Attention: Ania Dorocinska
Your Reference: SSD-9394

**TAMWORTH REGIONAL COUNCIL SUBMISSION - STATE SIGNIFICANT DEVELOPMENT -
BAIADA INTERGRATED POULTRY PROCESSING FACILITY - 1154 GUNNEDAH ROAD,
WESTDALE**

19 August 2019

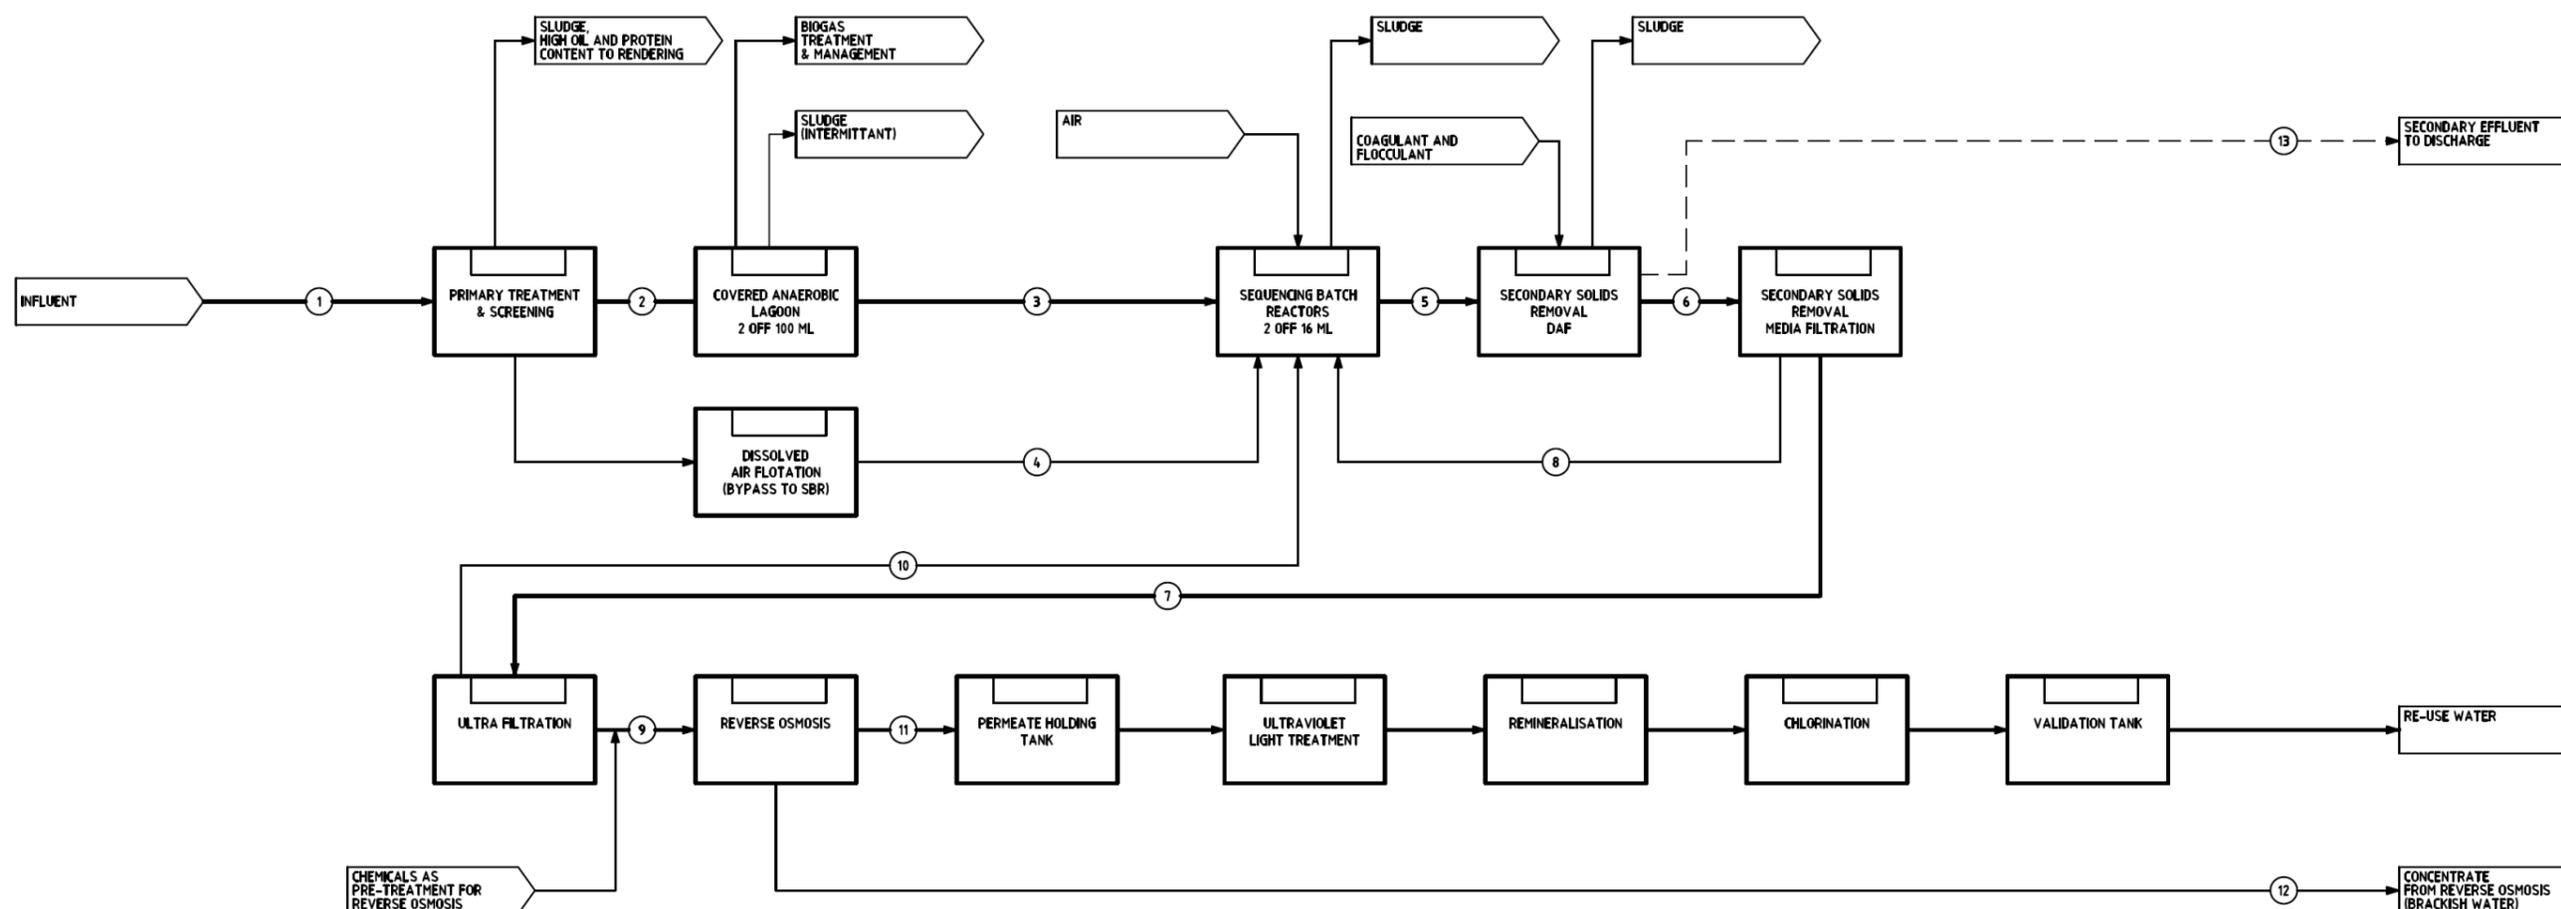
- The process flow diagrams provided for the wastewater treatment system in the EIS indicate that there will be sludge from the Covered Anaerobic Lagoon, the Sequencing Batch Reactors, and the Secondary Solids Removal DAF. Section 4.14.3 indicates that the wastewater treatment system generates "a very small amount of solid material" and this "solid material is biological in nature, with some trace elements (mostly phosphorus) and is suitable for the beneficial application to land." Although the EIS states that this waste stream is "suitable" for beneficial land application, it does not specifically advise where the waste sludge streams will be disposed of, nor does it make a commitment to disposing of this waste by beneficial application to land.

The environmental assessment should identify each of the sludge streams, provide expected volumes produced by each, and nominate the final disposal points for each stream, so that the impact of the proposed disposal may be properly understood and assessed.
